**Modification of Residential Subdivision
Lot 5 DP 788159, The Park Drive, Sanctuary Point**

Please find below Council's detailed submission to the proposed s. 75W modification to approved residential subdivision DA 485-12-2002.

Submission to DA 485-12-2002 MOD 1: 50 Lot Residential Subdivision Nadine St, Sanctuary Point

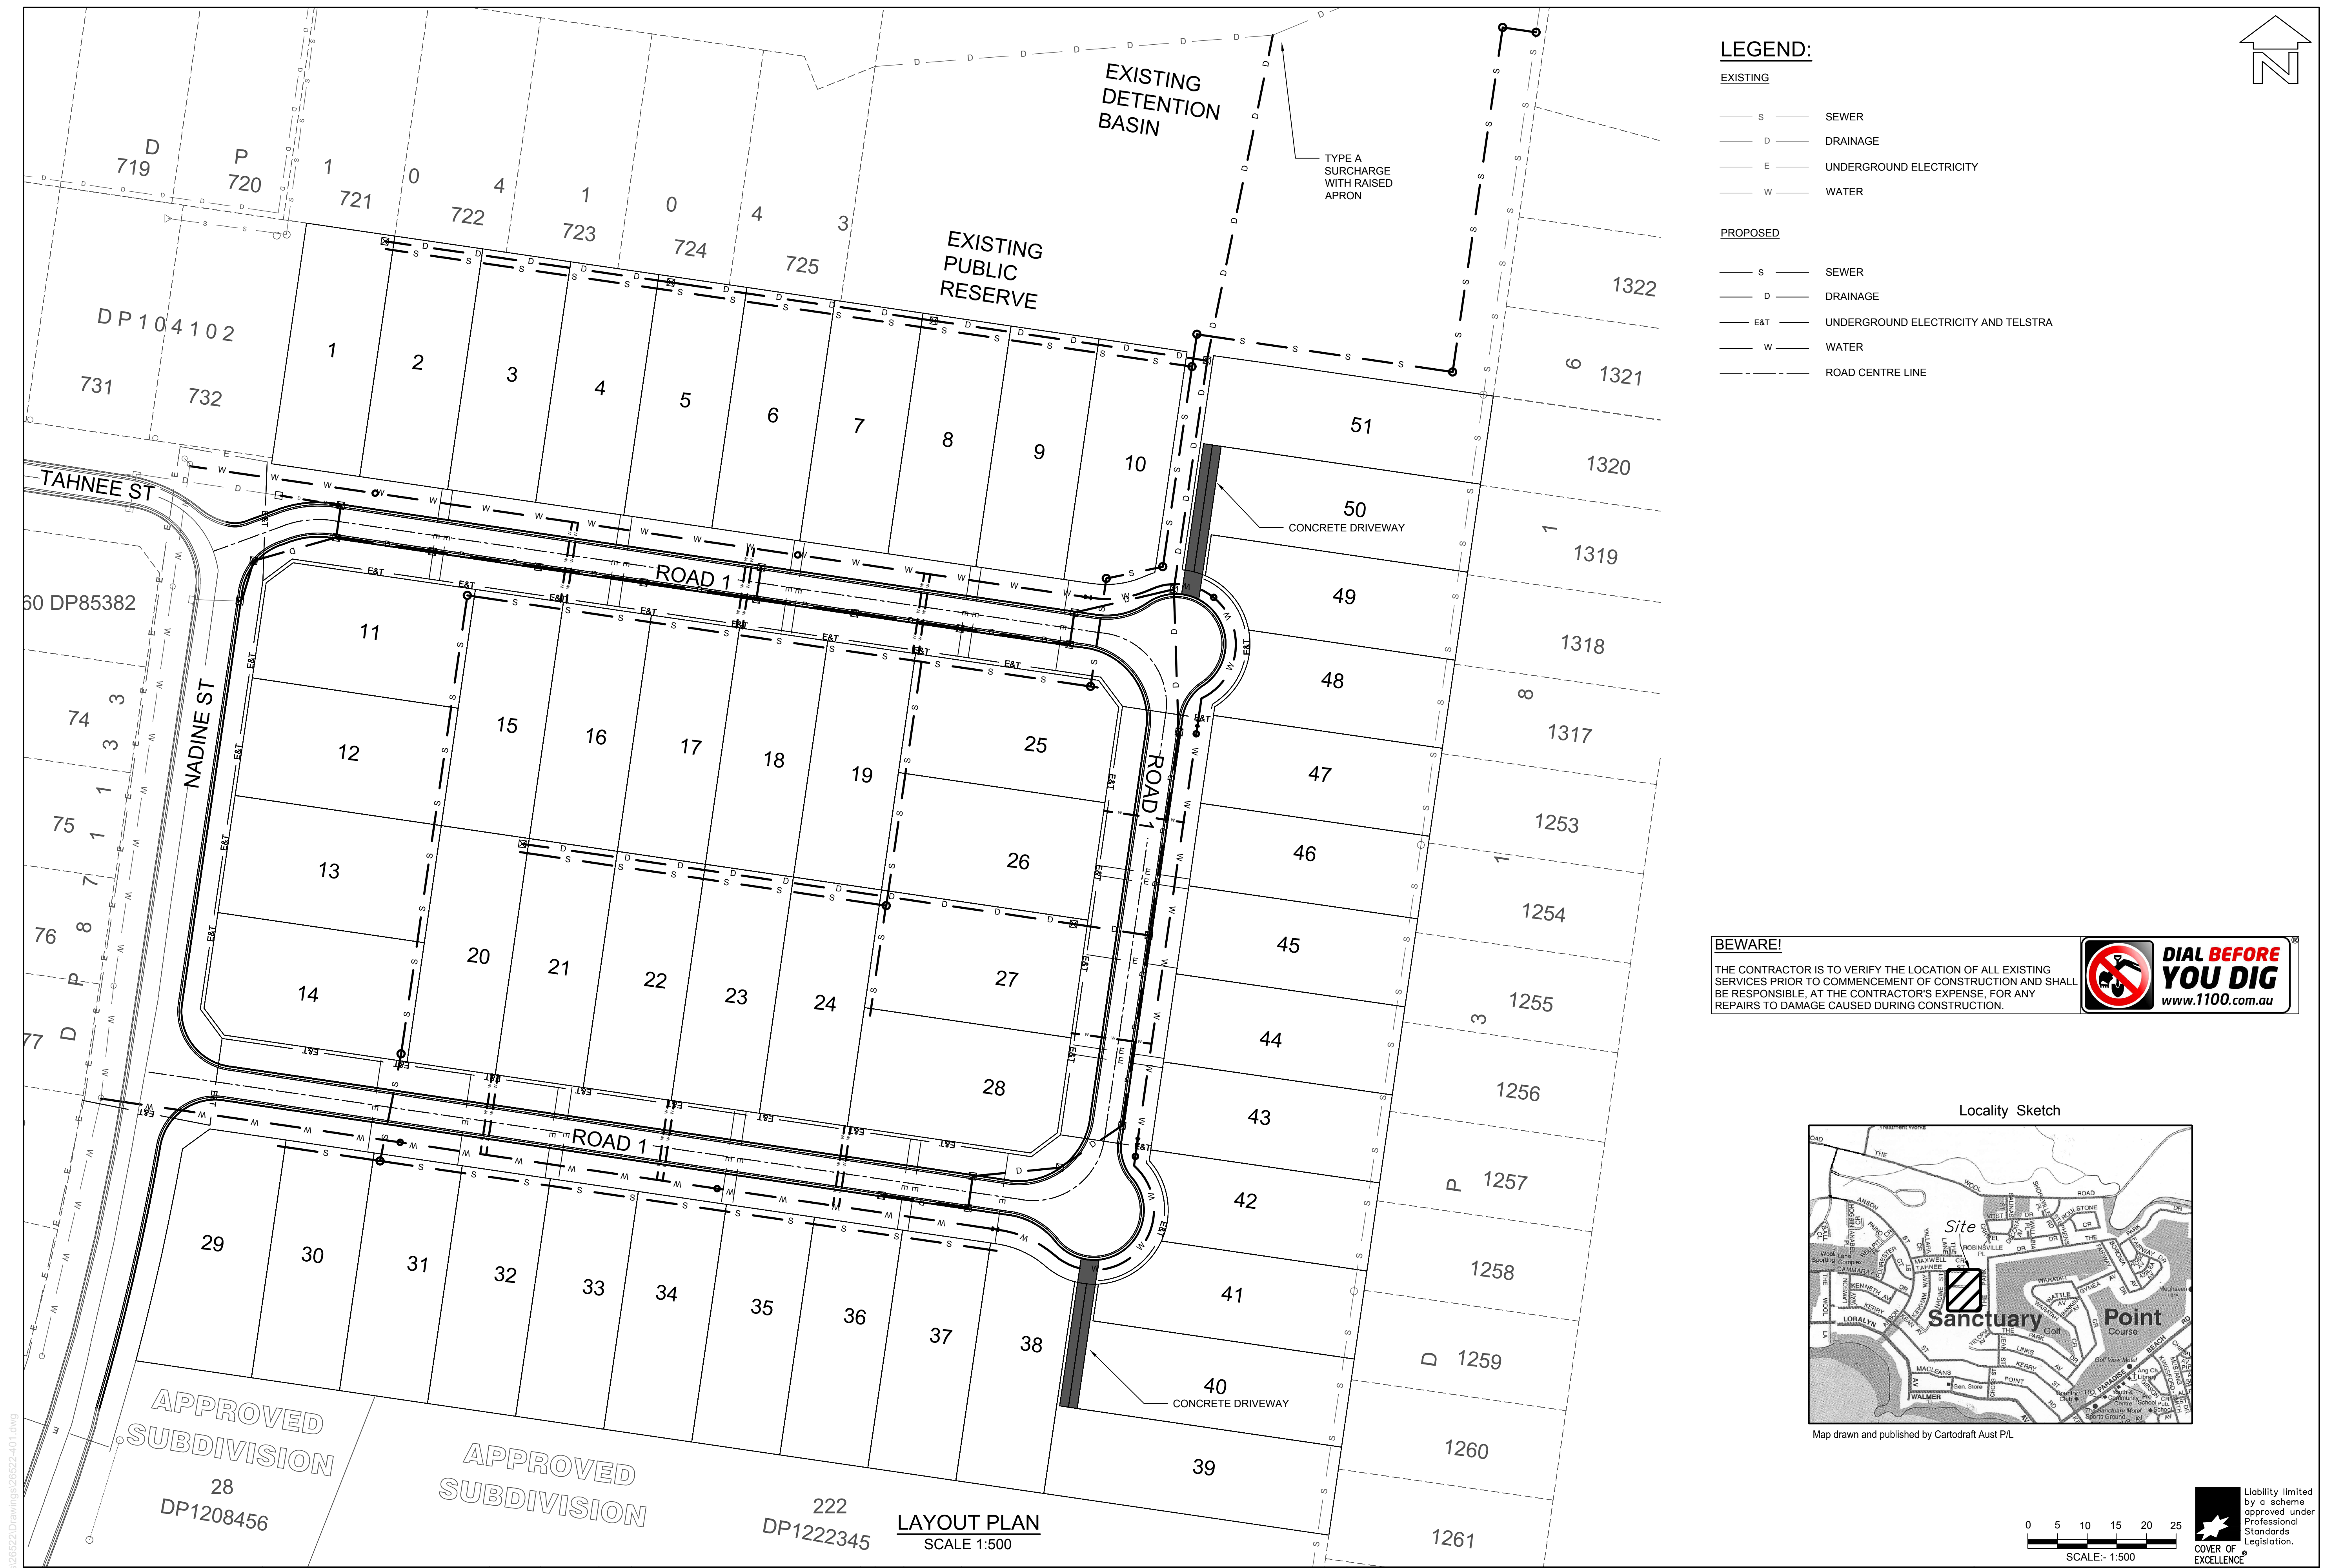
- Have 2m access handles. SDCP 14 requires 4m access handle. As this is not been provided reciprocal **rights of way are required** to be shown on the plan.
- Are oriented east-west;
- Have a width of 15m;
- Achieve the 650m² minimum lot size, without handle, required by the SDCP14 Chapter G11 5.13;
- **Do not** achieve a minimum buildable area of 15m x 15m within the BCA boundary setbacks as outlined in the SDCP14 Chapter G11 5.13;
- **Do not** provide 4m corner splays to facilitate access and manoeuvring.

Inter-allotment drainage is required to drainage Lots 1 – 10, 50 and possibly Lot 49. No information has been provided as to how these lots will be connected to the proposed drainage reserve.

Supporting details such as, verge widths, pavement widths, radii of 'knuckles' and cross sections showing location of serves and landscaping have not been provided.
